**CITY OF PORTLAND, MAINE
DEVELOPMENT REVIEW APPLICATION
PLANNING DEPARTMENT PROCESSING FORM**

2002-0170

Project Name/Description

Approval Conditions of DRC

Drawing Name:	Grading & Drainage Plan
Project:	LOT 4 - NORTHGATE FARMS, PORTLAND

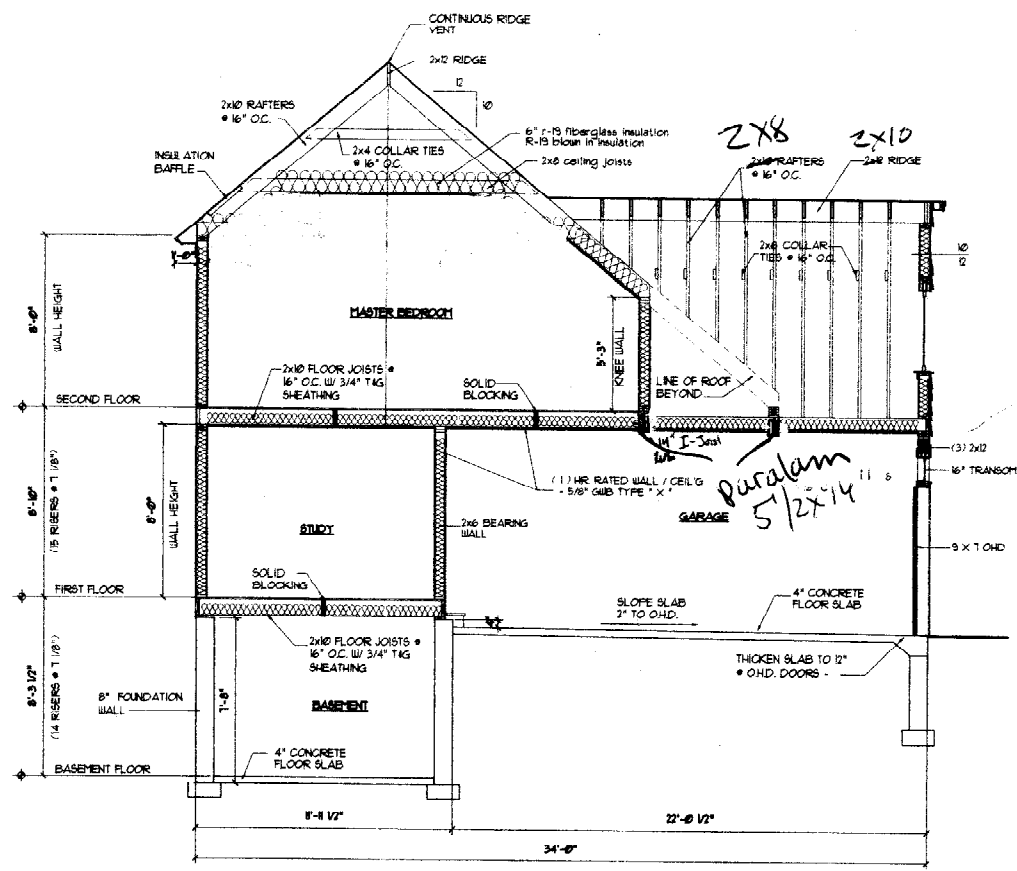
- 1 Grading does not match the proposed grading on the subdivision plans. This is acceptable, being that the intent and overall drainage flow directions are not changing.

- 8 The site contractor shall establish finish grades at the foundation, bulkhead and basement windows to be in conformance with the first floor elevation (FFE) and sill elevation (SE) set by the building contractor to provide for positive drainage away from entire footprint of building.

- 9 The Development Review Coordinator reserves the right to require additional lot grading or other drainage improvements as necessary due to field conditions.
